Community Services Planning Department

Project Name: [Kroger Fulfillment Center - Site Development Plan](#)
Project ID Number: 2011731

The City of Fountain has completed its review of the Kroger Fulfillment Center - Site Development Plan for the property generally located at 702 BANDLEY DR. The following are items that need to be corrected and/or modified. Once you have made the revisions, please resubmit all project documents through the project portal, using the 'Review and Resubmit' button provided on your project page. Please provide a response to all comments as part of the resubmittal process. You can "reply" on the "response tab".

C-202

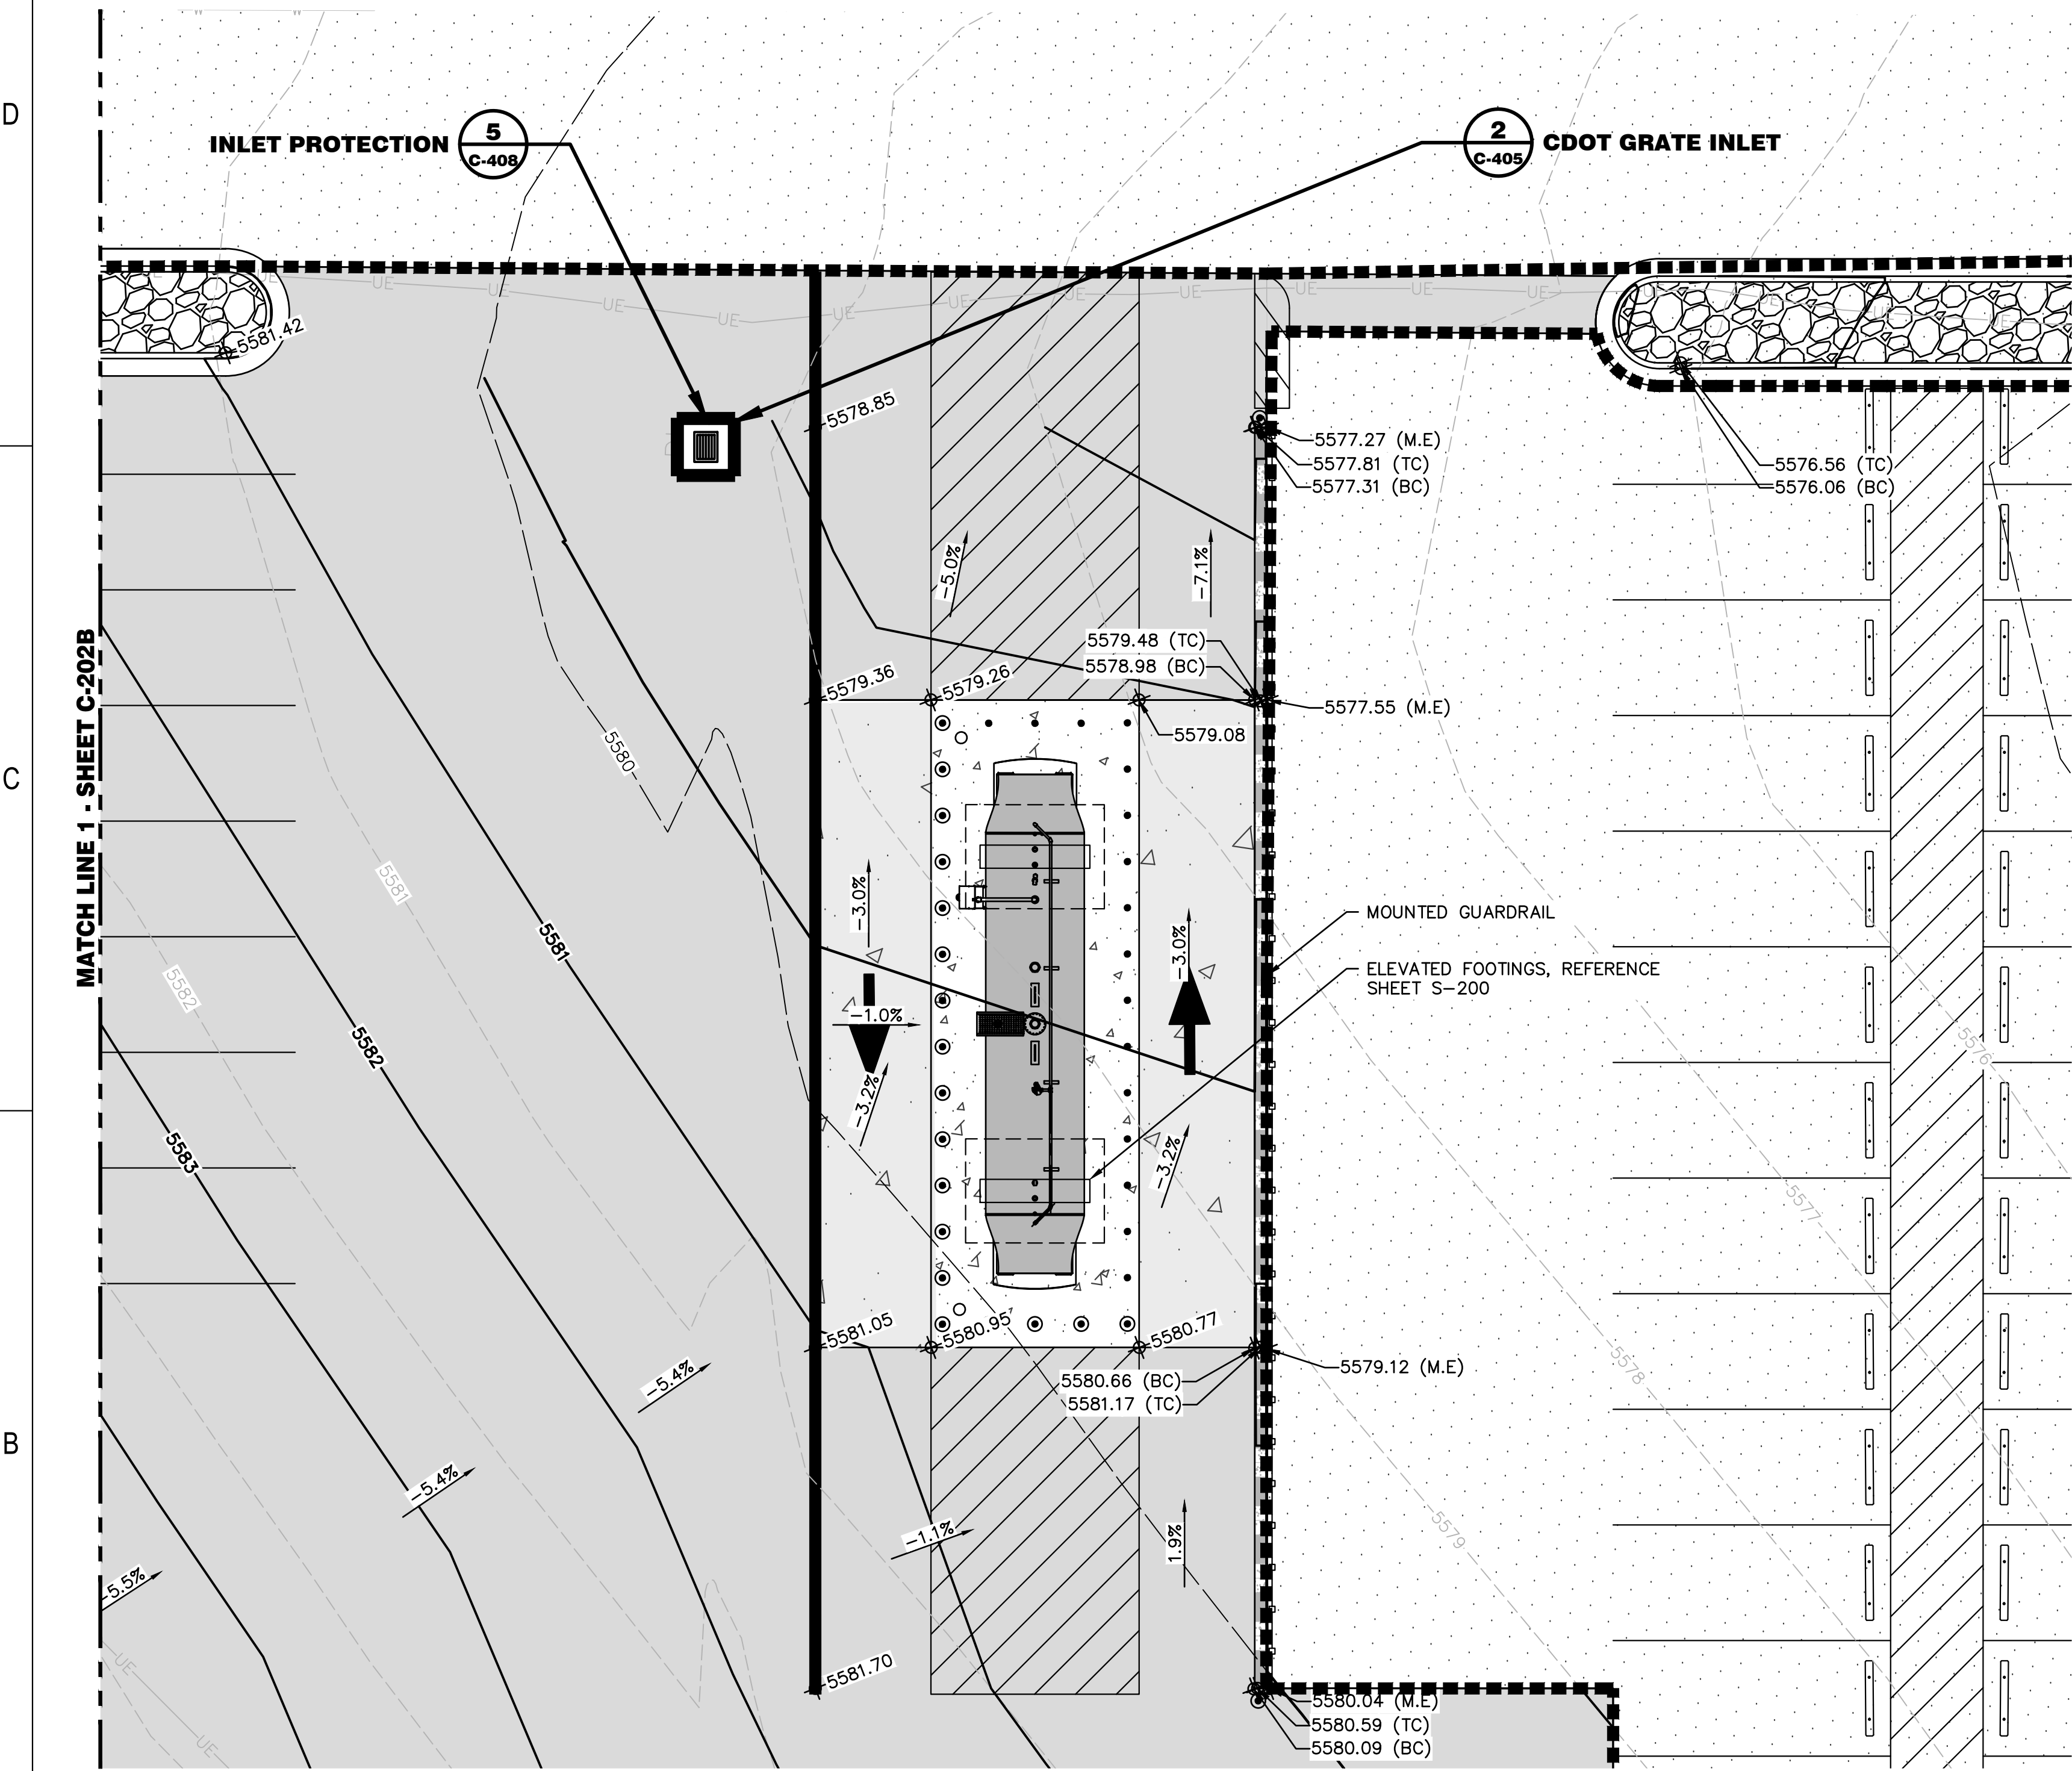
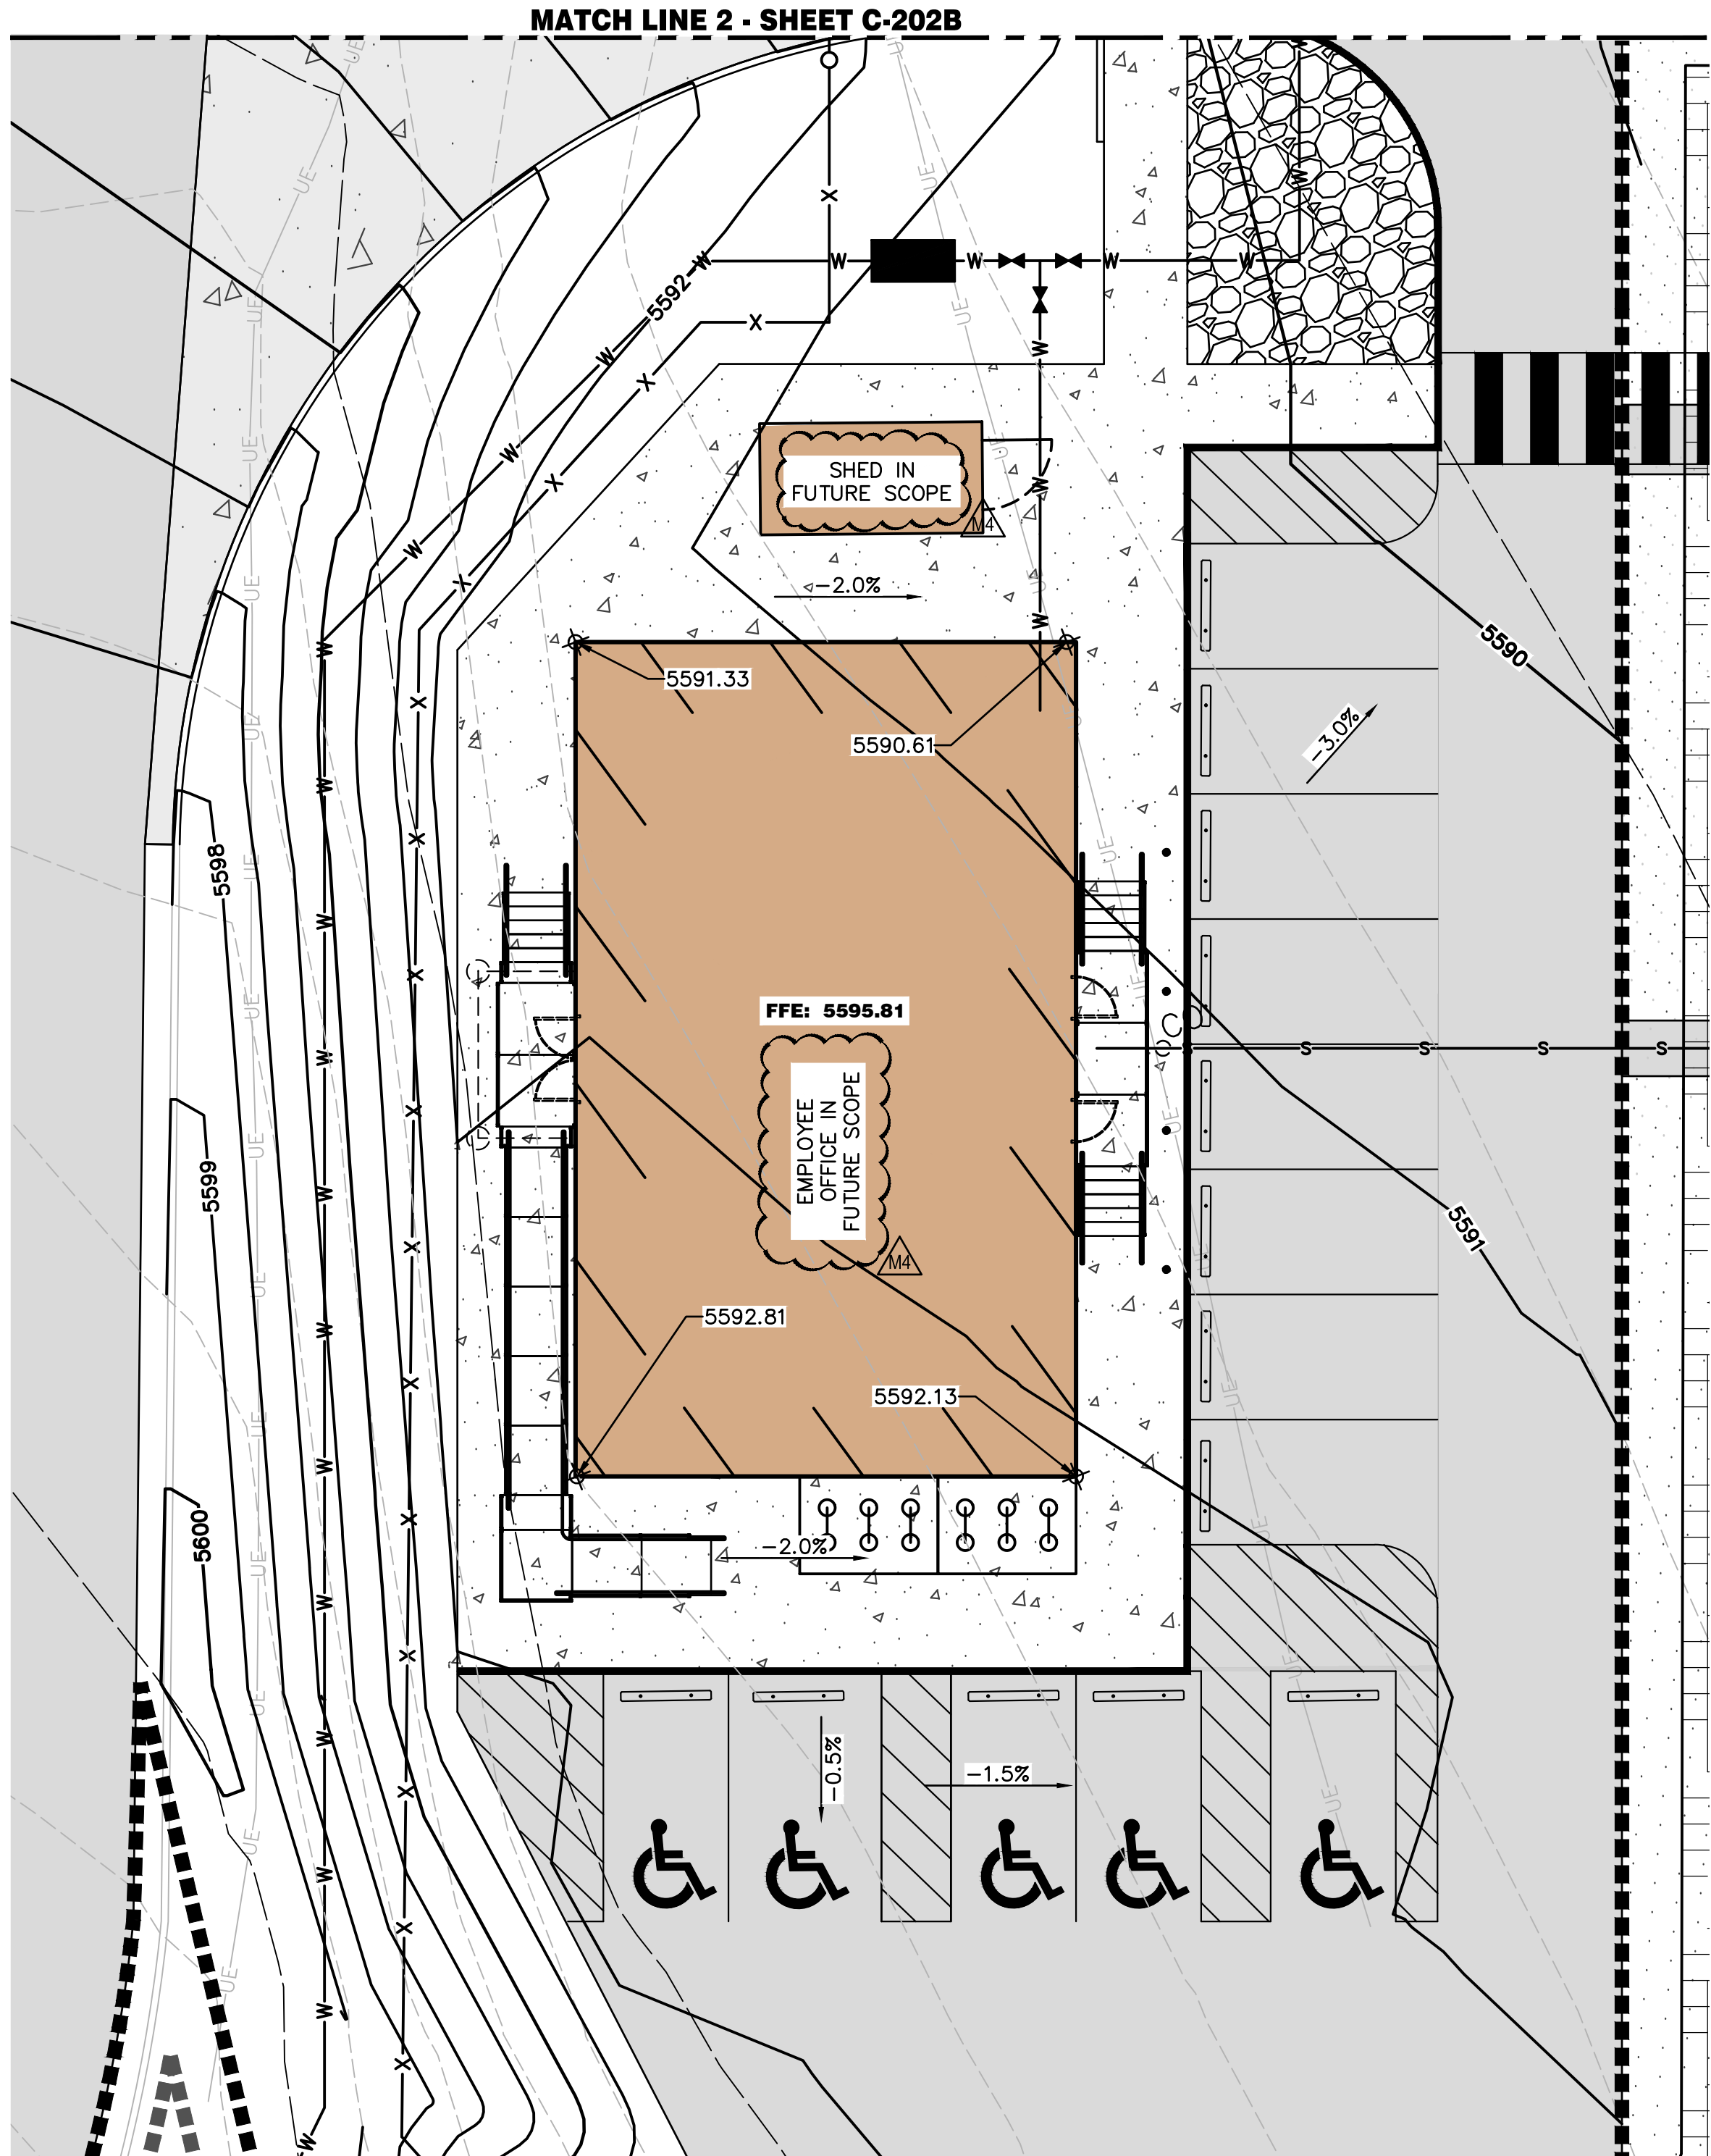
City of Fountain Ben Sheets 719-322-2000 bsheets@fountaincolorado.org	As noted on sheet 202A, the grading and erosion control plans do not reflect Fountain stds. A review of the plans in this set has not been conducted as a result. Additional comments can be expected.
--	---

The grading and erosion control plans in this plan set do not follow the Fountain adopted grading and erosion control plan requirements as set forth in the Colorado Springs Stormwater Construction Manual (SCM). A review will not be conducted until such time as it follows the stds. Also, please remove all references to the County or other entities not associated with this project.
